Our Ref: AL/85/19/PL

**Town & Country Planning Act 1990 (as amended)
Town and Country Planning (Development Management Procedure) (England) Order 2015
Application for Planning Permission**

Development Retention of existing School Shop. This application is a Departure from the Development Plan.

Location Aldingbourne Nurseries Church Road Aldingbourne

Title
PROPOSED FLOOR PLAN

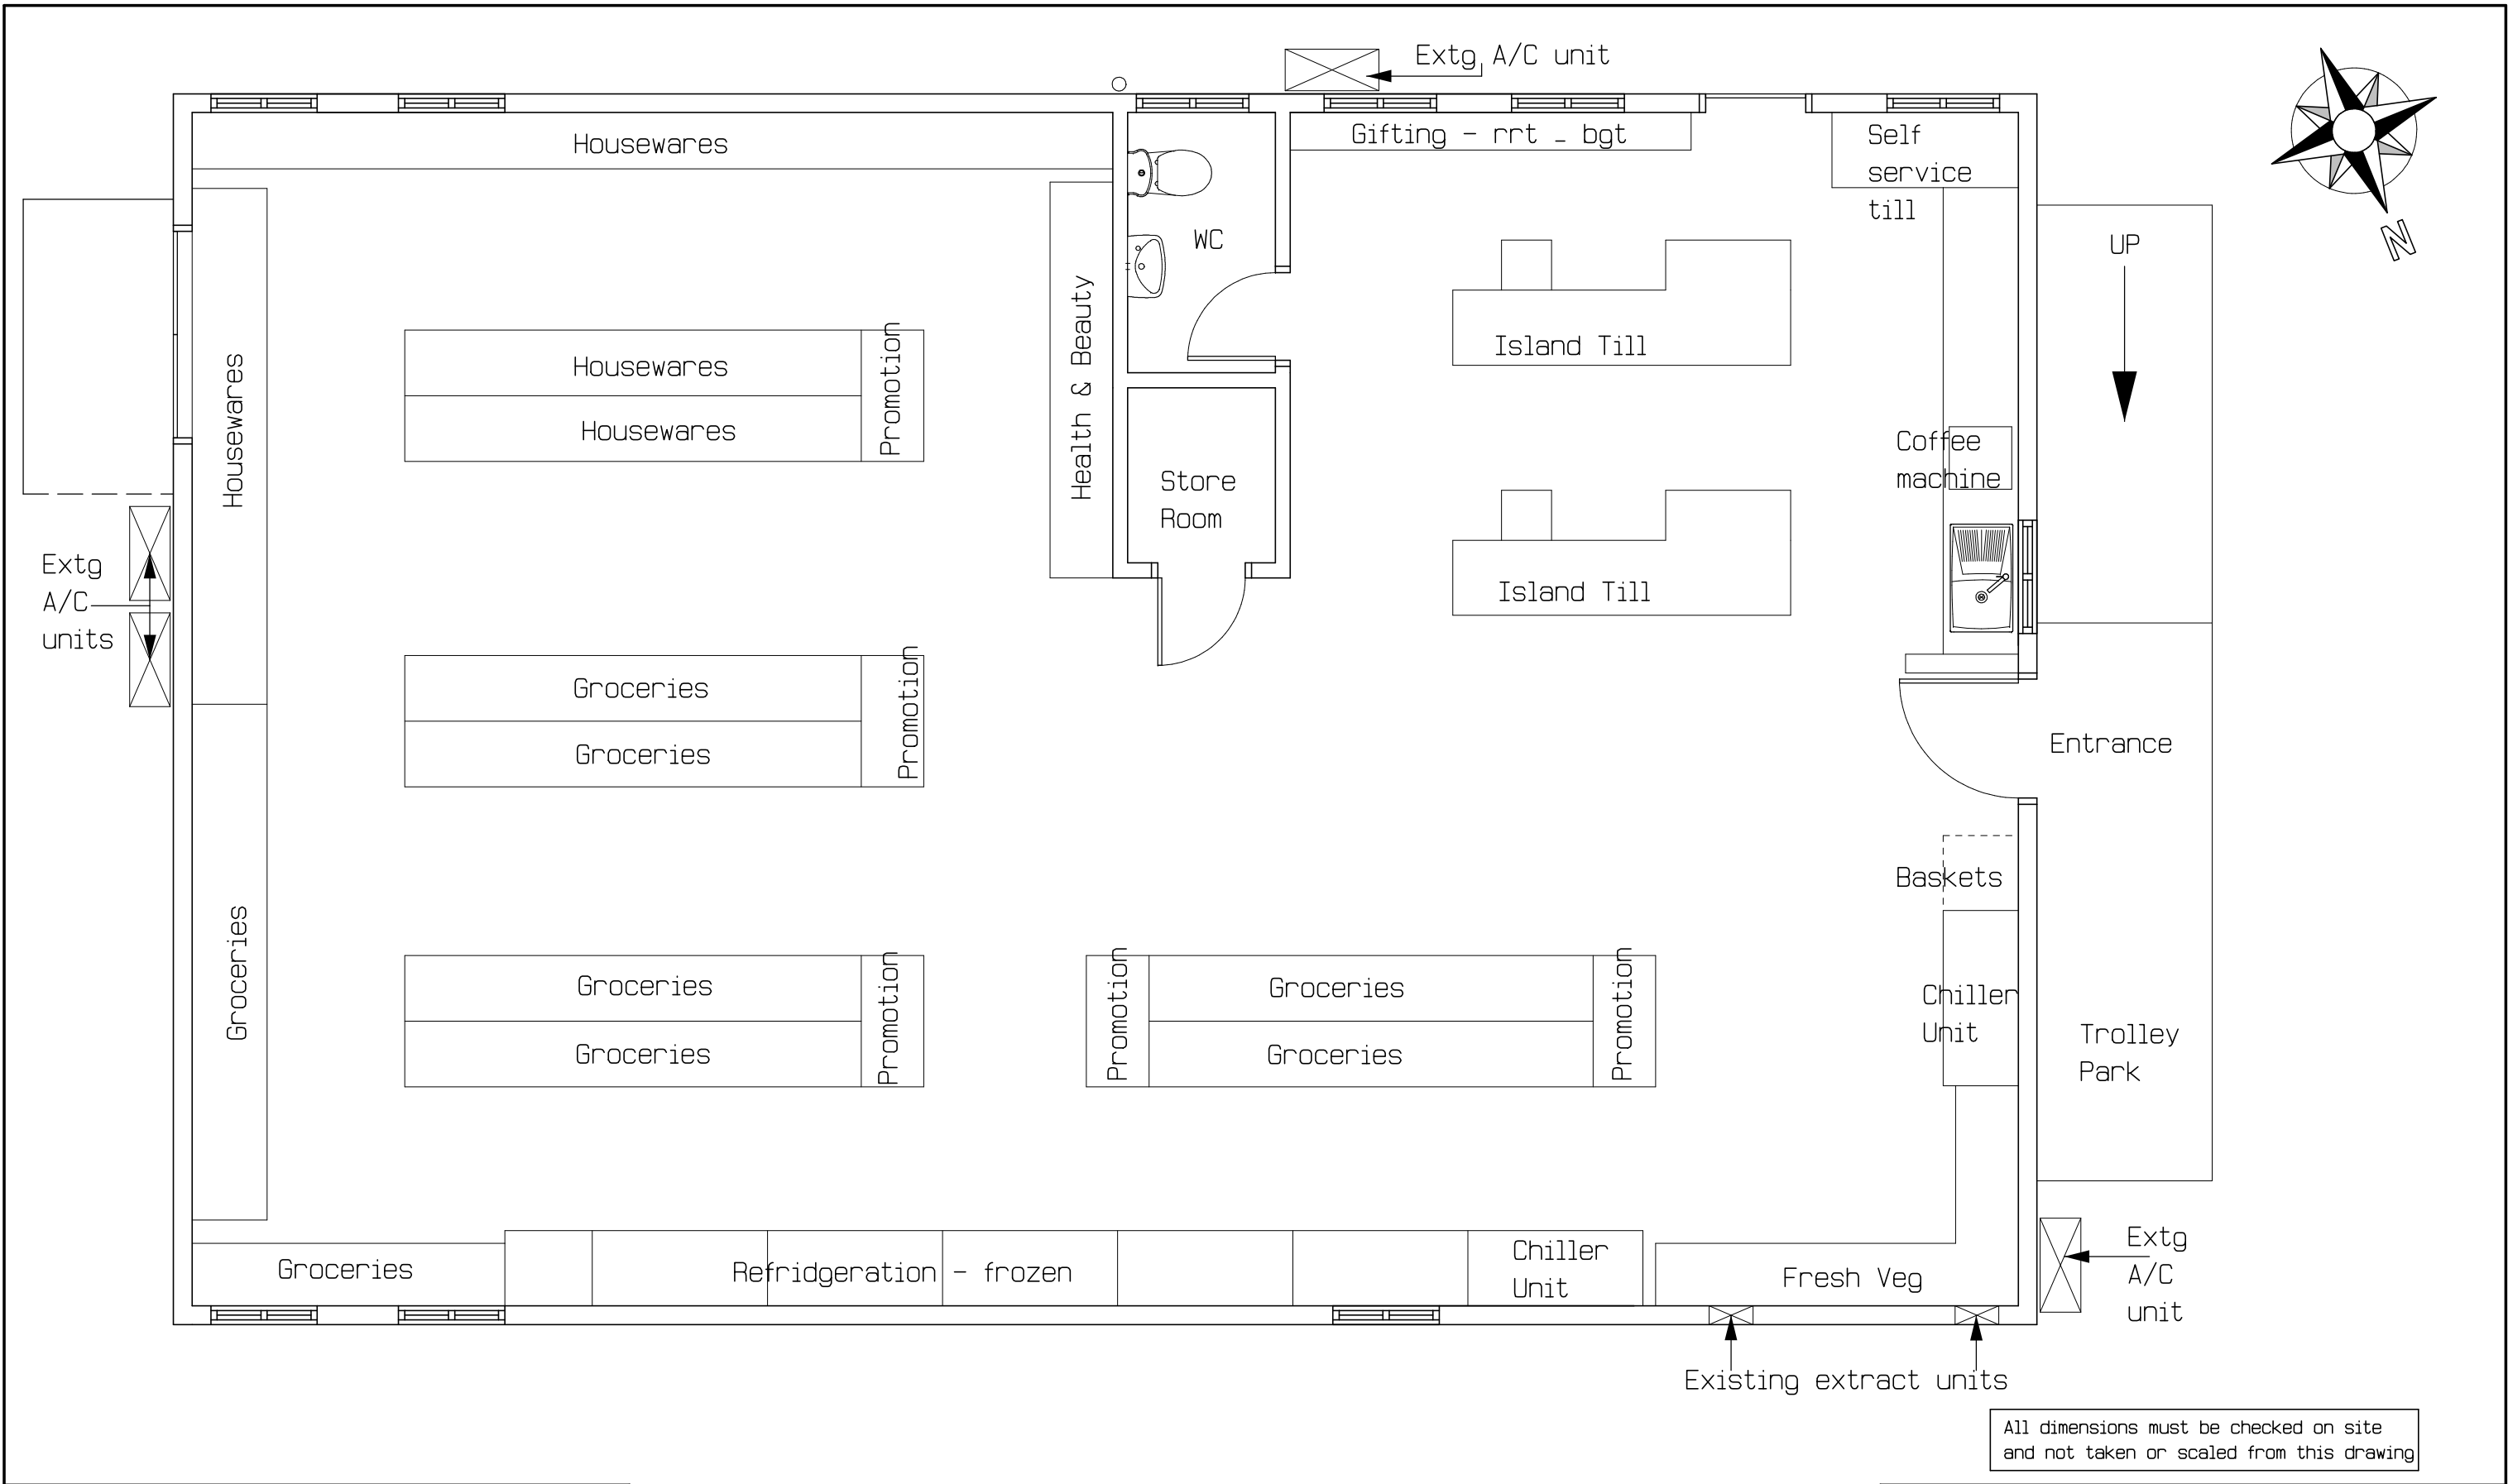
Please confirm if there are existing extraction units in the chiller unit and refrigeration-frozen area.

The location, block, floor plans and elevations do not scale correctly. Please amend accordingly. The fee can't be confirmed until these plans scale correctly.
